Subject: Response: Planning Consultation BR/194/17/PL - Promenade opp. Clarence Road, The Esplanade, Bognor Regis, PO21 1LX

APPLICATION BR/194/17/PL

Site Address: Promenade Opposite Clarence Road The Esplanade Bognor

Your Ref
BR/194/17/PL
Our Ref
PLAN-019149
Date
15/08/2017

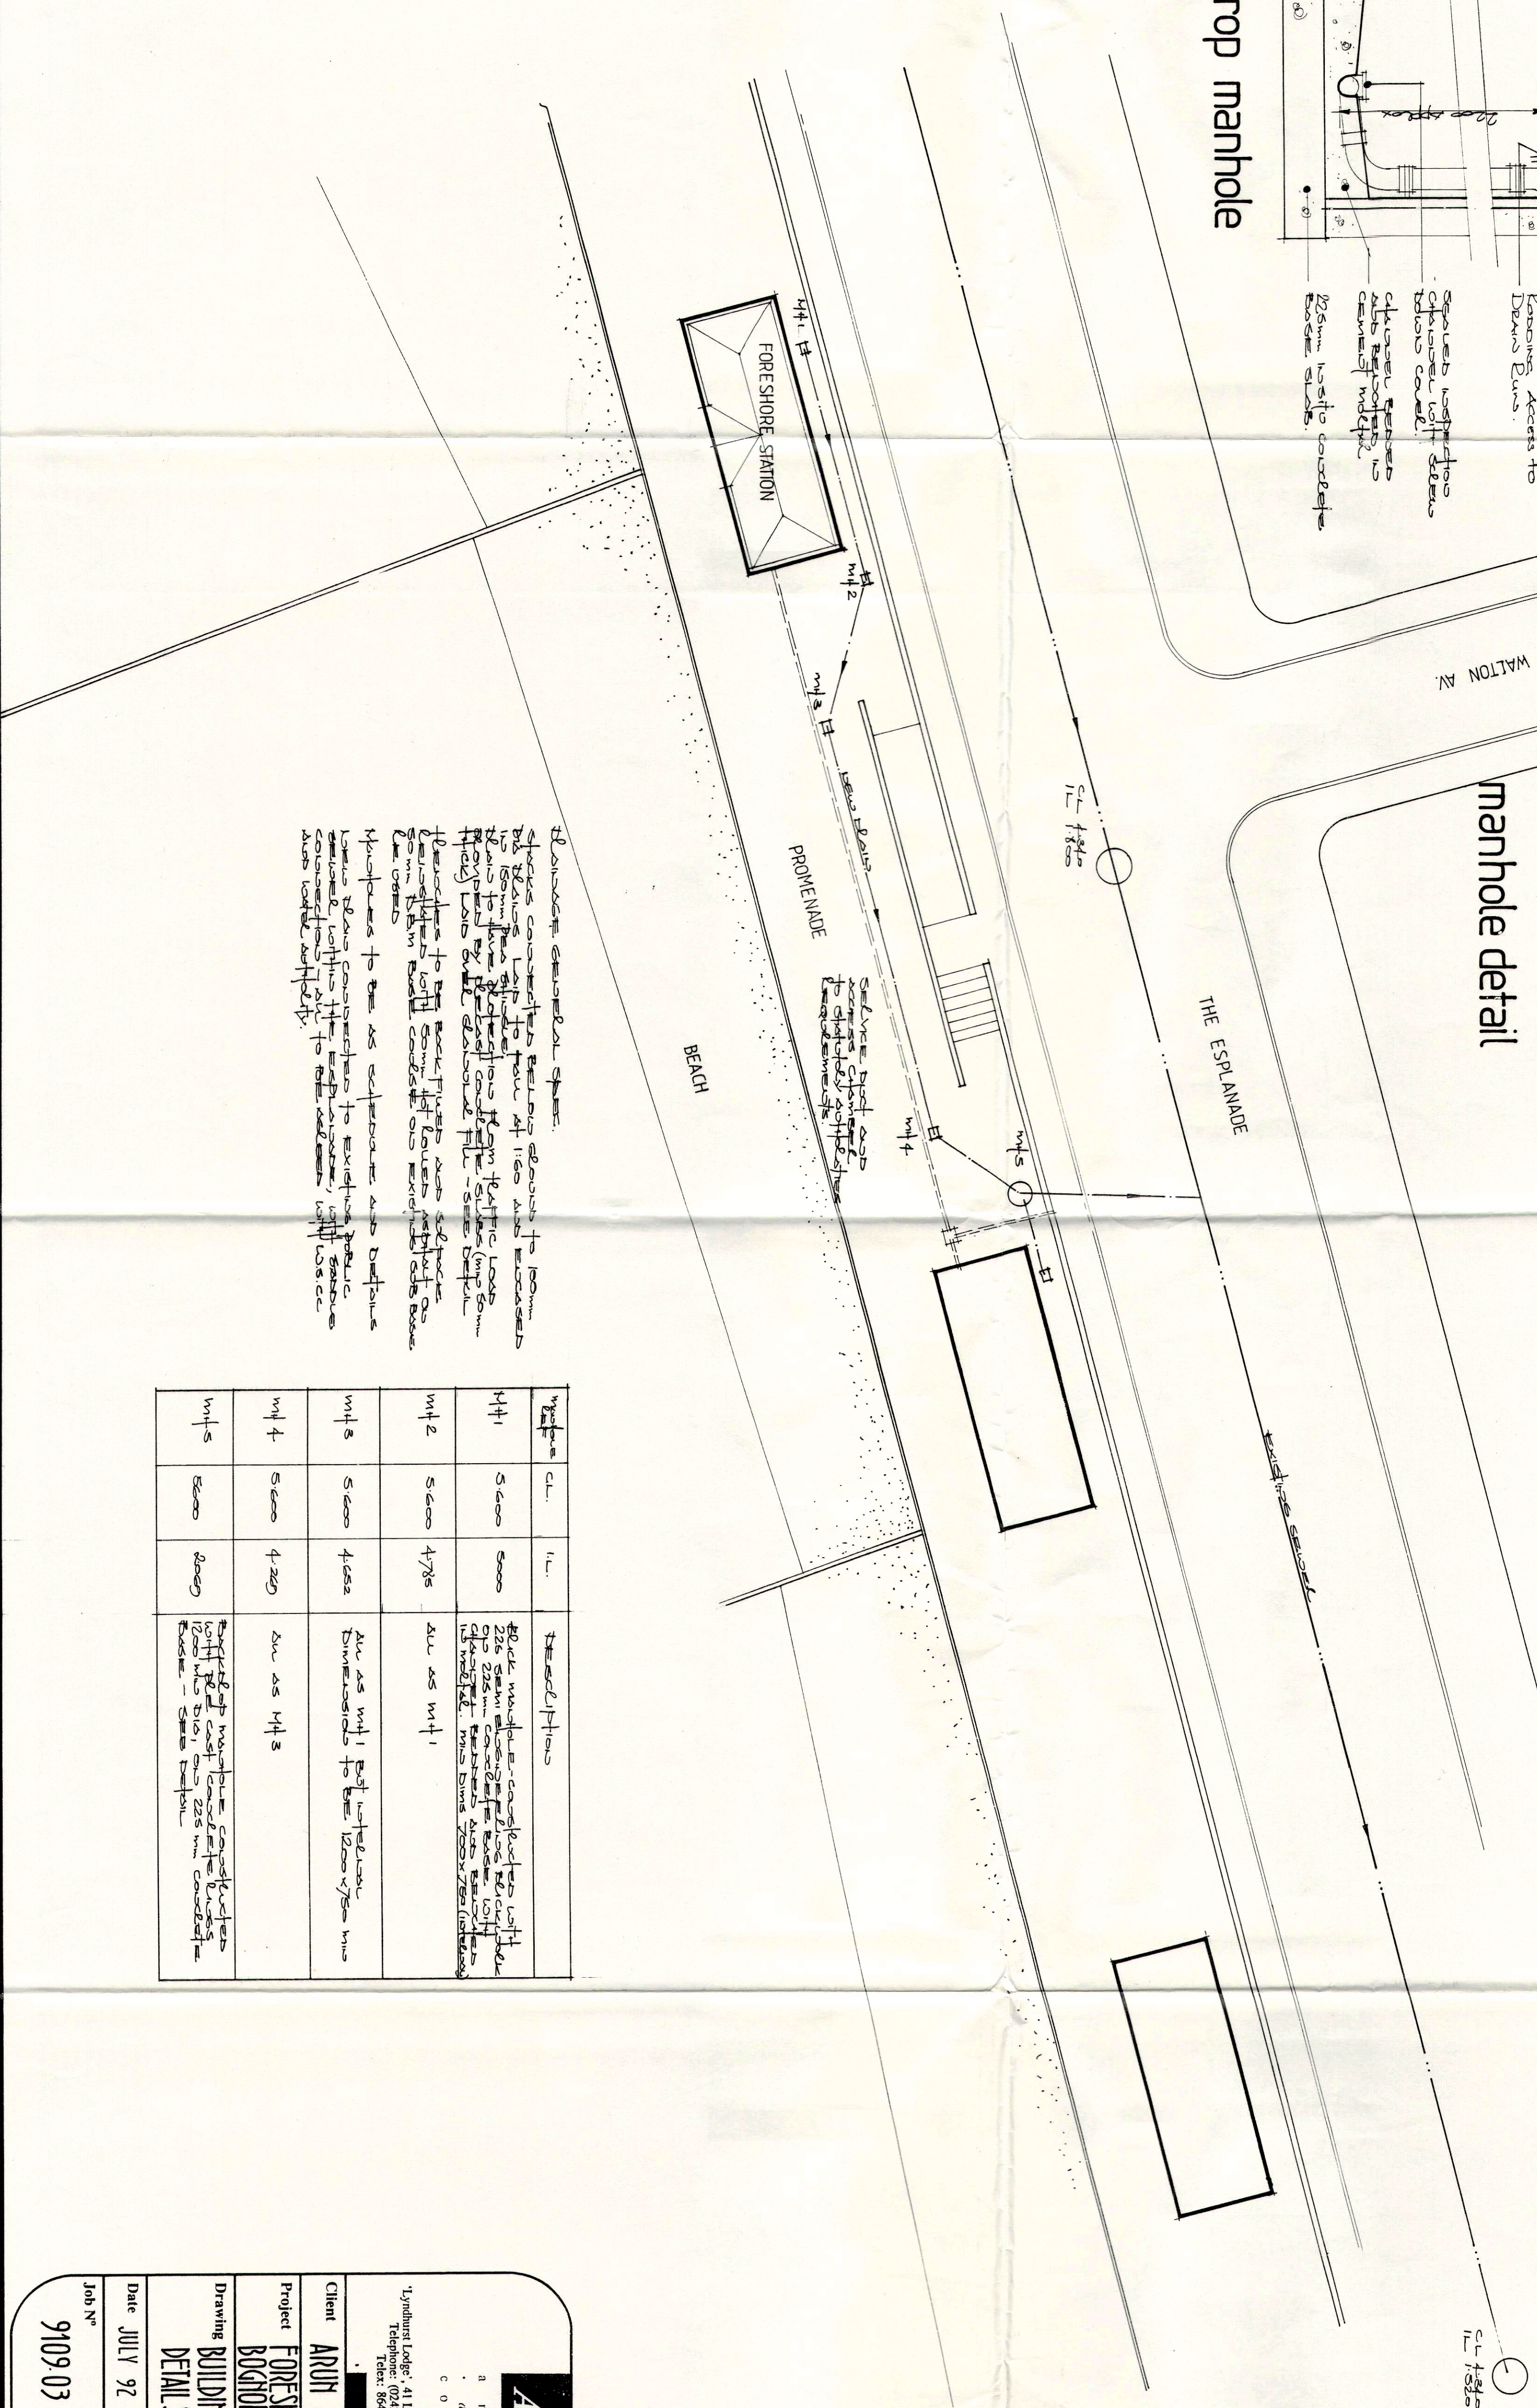
Thank you for your letter of 13/07/2017. Please find attached a plan of the sewer records showing the approximate position of public sewers and a critical foul rising main in the vicinity of the site.

There is a critical surface water outfall sewer crossing the site. The exact position of the public sewers must be determined on site by the applicant before the layout of the proposed development is finalised.

-the 675 mm diameter surface water sewer and the 600 mm diameter foul rising main require a clearance of 4 metres either side of the sewer to protect them from construction works and allow for future access for maintenance.

-No development or new tree planting should be located within 4 metres either side of the centreline of the public sewers or rising main

-No new soakaways should be located within 5 metres of a public sewer or rising main.

In order to protect the drainage apparatus, Southern Water requests that if consent is granted, a condition is attached to the planning permission. For example "The developer must advise the local authority (in consultation with Southern Water) of the measures which will be undertaken to protect the public sewers, prior to the commencement of the development."
